Current Zoning: N1-A (Neighborhood 1-A)
Proposed Zoning: CR (CD) (Regional Commercial, Conditional)

Approximately 4.85 acres located west of Steele Creek Road and north of the Interstate 485 ramp.

The petition proposes to develop a vacant property in the Steele Creek community with up to 122,500 square feet of self-storage uses.

Staff recommends approval of this petition upon resolution of outstanding issues related to site and building design.

REZONING CASE #: RZP-2023-092

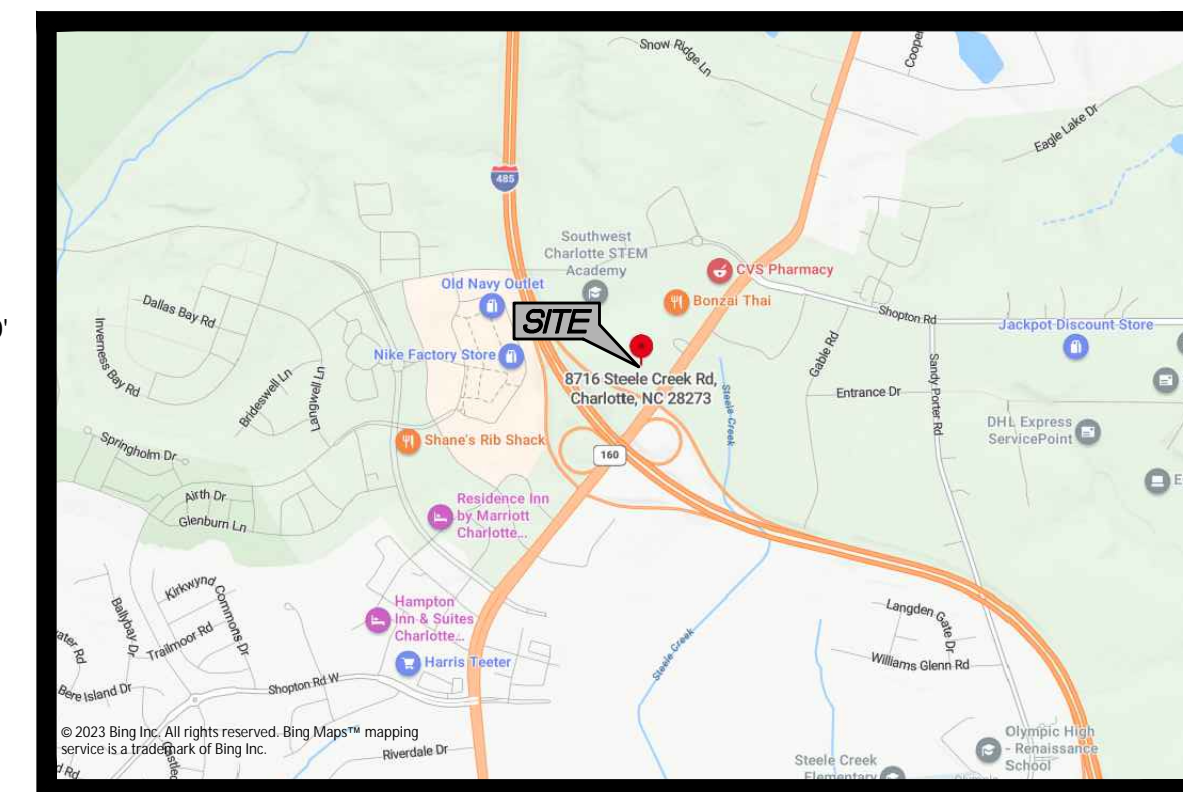
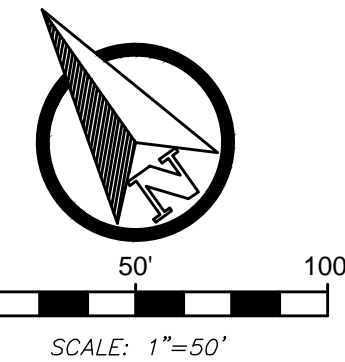
1. Adjust the square footages so that the maximum gross floor area equals the sum of the climate controlled self-storage and outdoor self-storage.
2. Show tree save area on site plan. This site is required to provide a minimum of 15% tree save.
